From: Bloomer, David <David.Bloomer@lancashire.gov.uk>
Sent: 10 January 2019 14:41
To: Adam Birkett
Cc: LHS Customer Service; planning
Subject: app3/2018/1179 Ribblesdale View, Chatburn

The proposal has previously received planning permission albeit with an amended housing style and layout and as such the principle of a small residential development of 4 dwellings has been accepted.

Proposed Site Layout

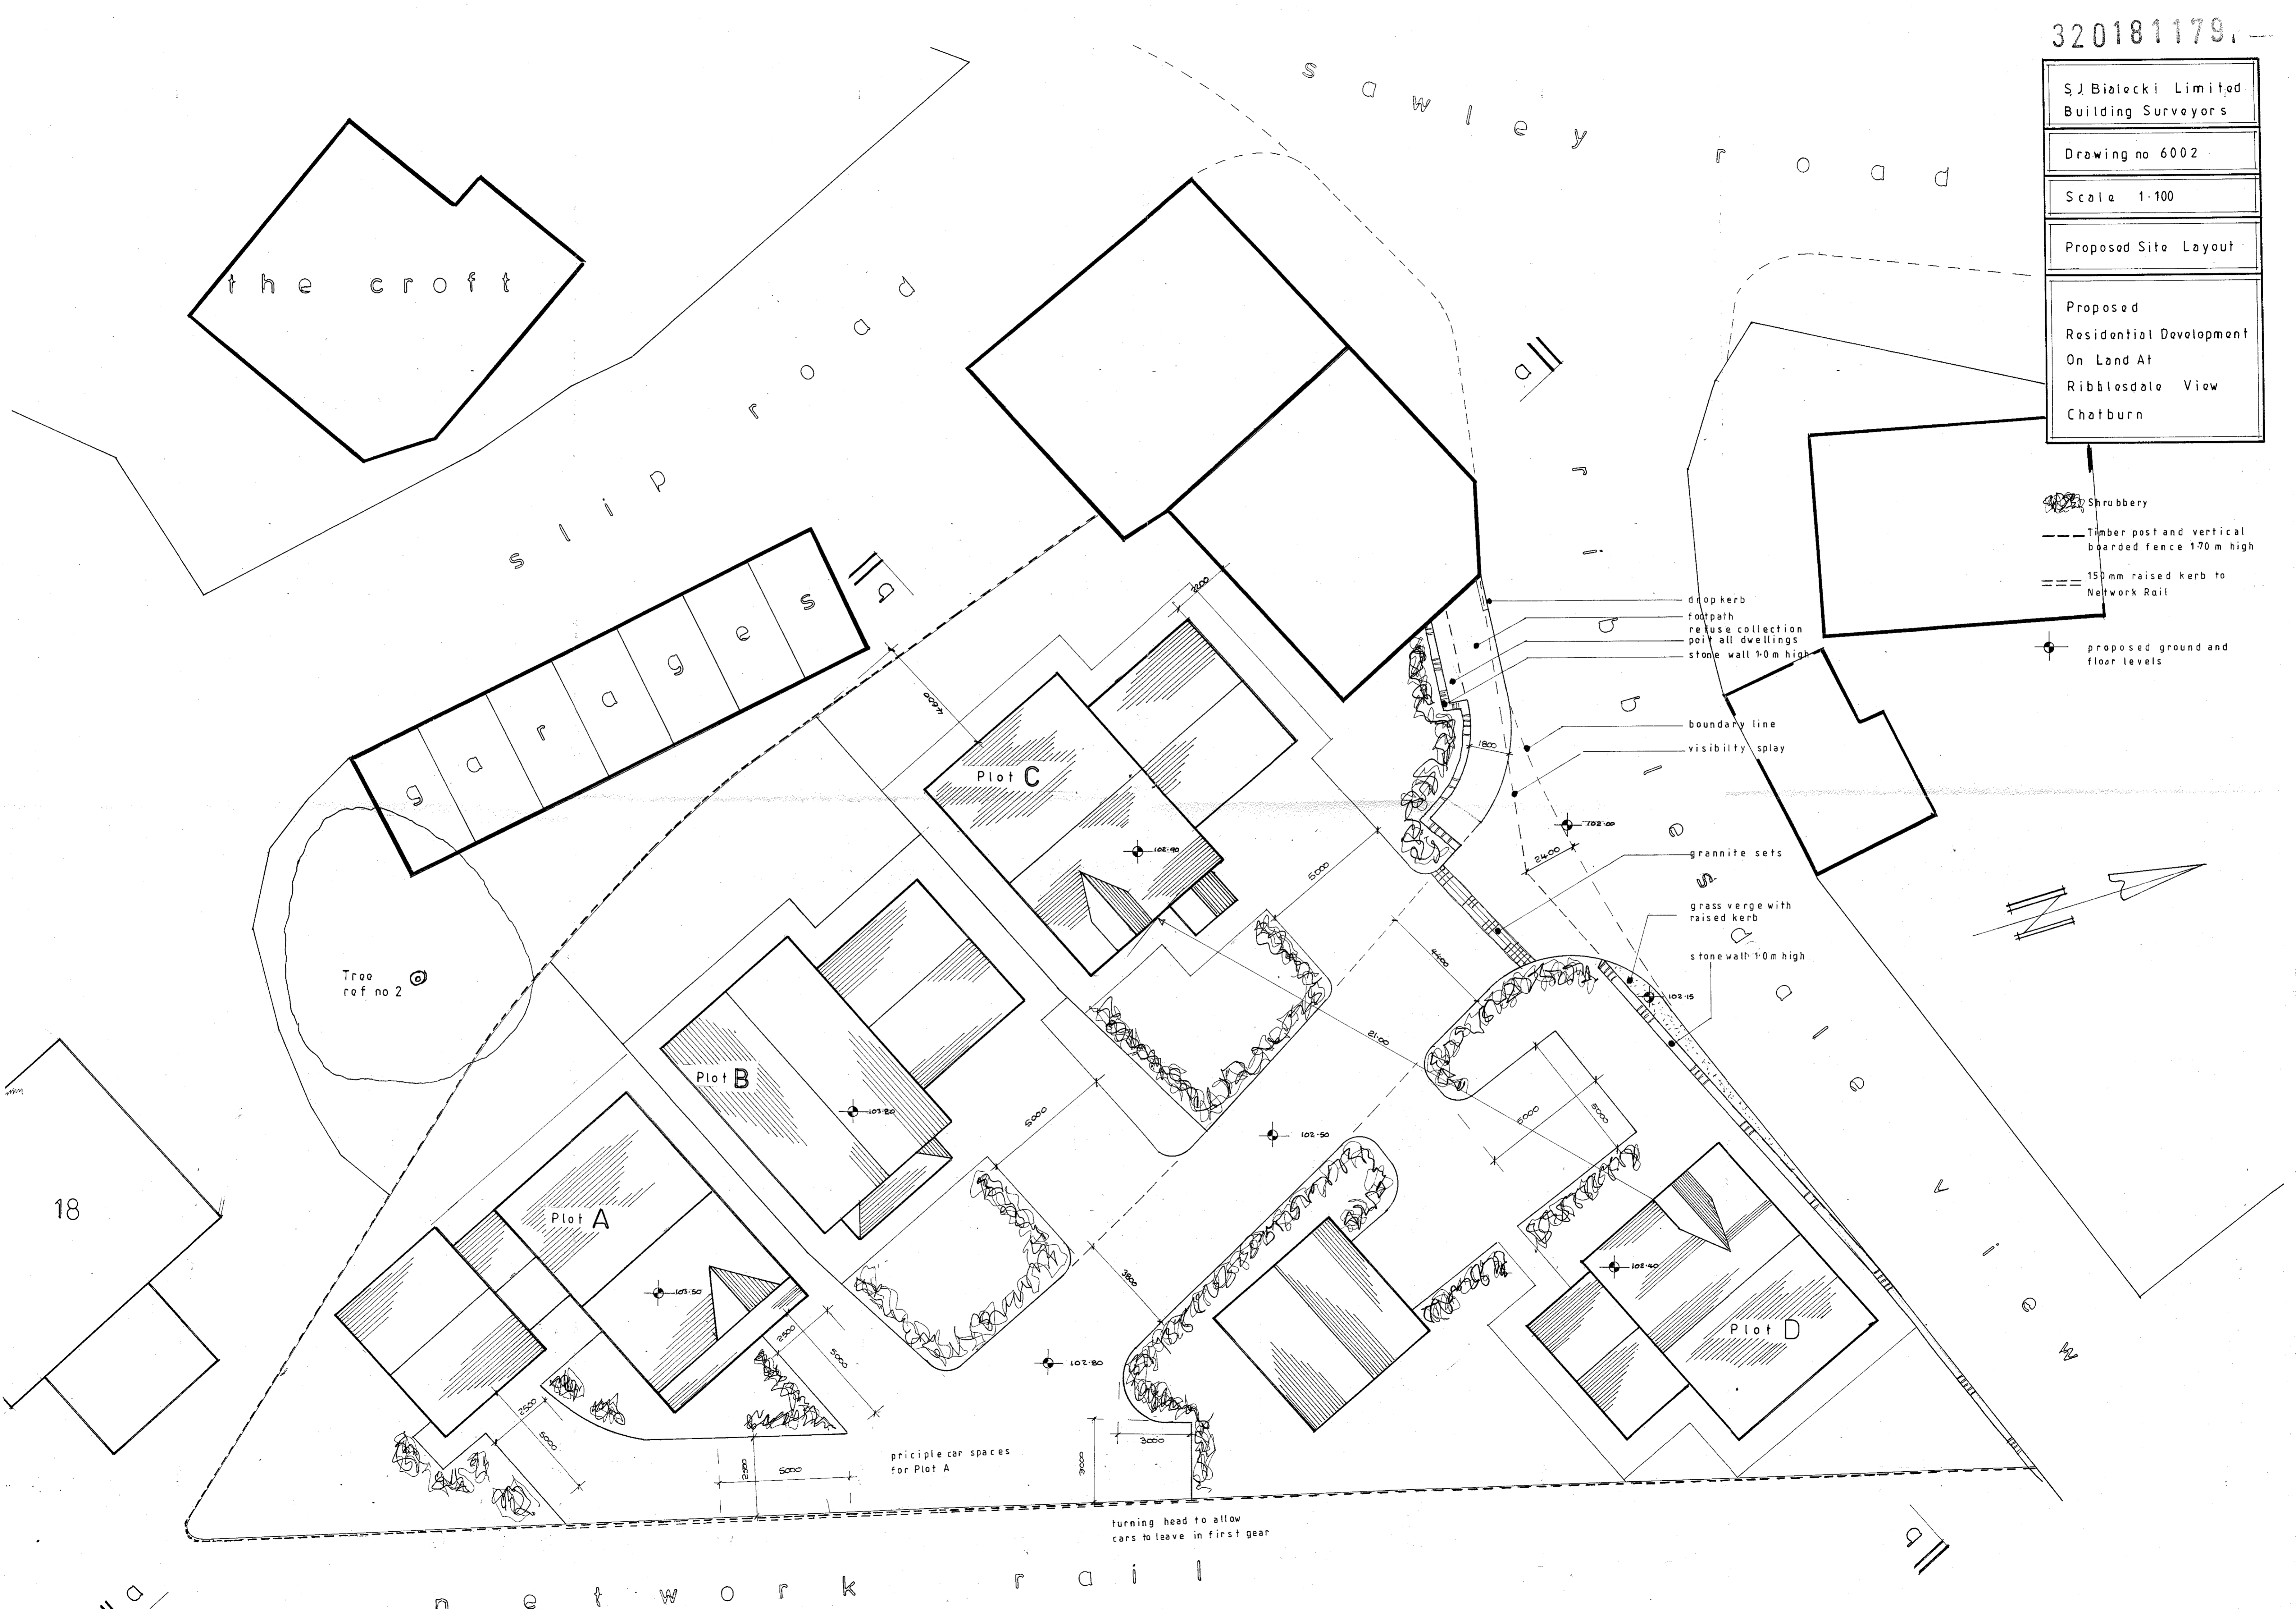
1 The applicant will need to provide an annotated plan showing the available sight lines at the proposed site entrance. I am particularly concerned re. the visibility splay to the east (right on exit) as the retained verge width appears to have narrowed over that previously approved. I have also noted the reduced height boundary wall but as it is a domestic boundary it is likely to be supplemented with planting or a secondary boundary treatment which would remove the ability to see over the wall

2 The footway provided to the west of the entrance is obstructed by a stone wall when entering the site. This wall should be removed and a dropped pedestrian kerb should also be provided similar to the one proposed on Ribblesdale View.
